QUICK QUACK

Constitution Colorado Springs, CO

QUICK QUACK CONSTITUTION
SITE PLAN

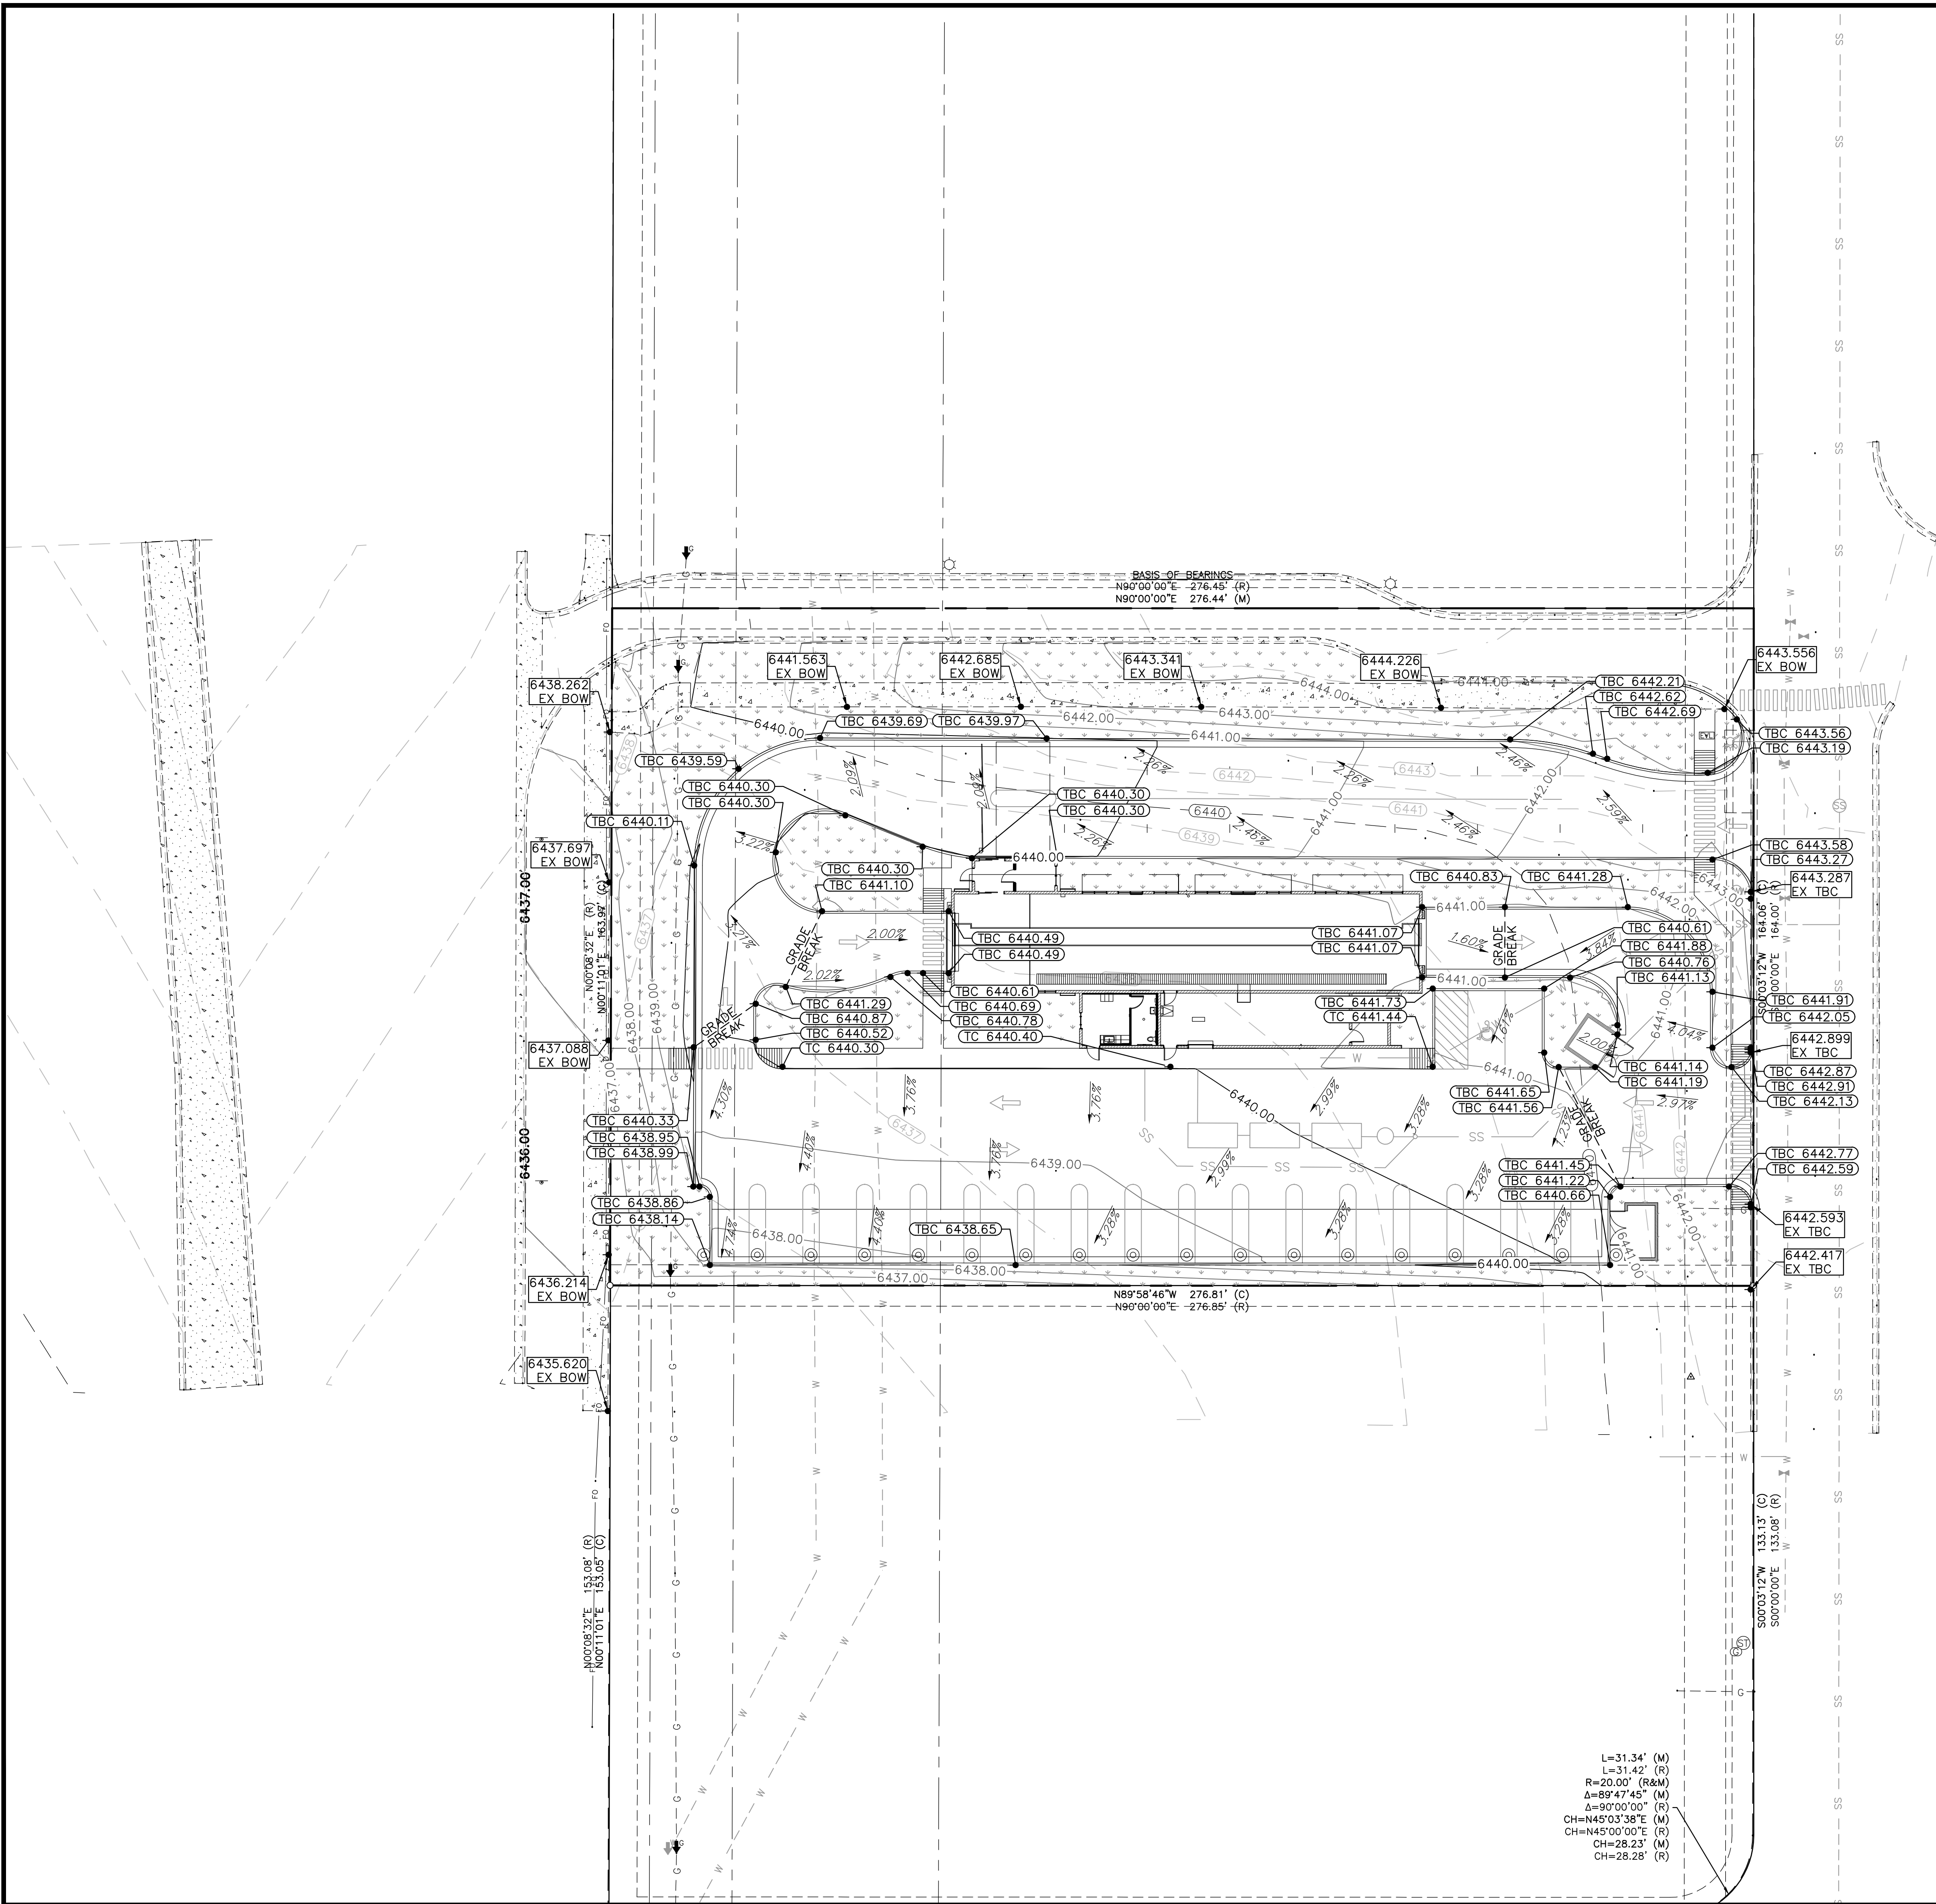
Replace with El Paso County.
The site is located within
unincorporated El Paso County.

provide the reception
number or plat
reference that
established these
easements

Canopies are
required to be 15'
from the front
property line or ROW,
please provide this
measurement.

Provide actual
distance structure is
from property line

revise line type or
update the legend.

update legend,
property lines no
correctly depicted

Label the radius.

Over 7 foot tall will
also be required to
show setbacks from
property lines.

Are these easements? The canopy
is considered a structure and
written permission from the
easement holder would be required
for the canopy to be located in an
easement.
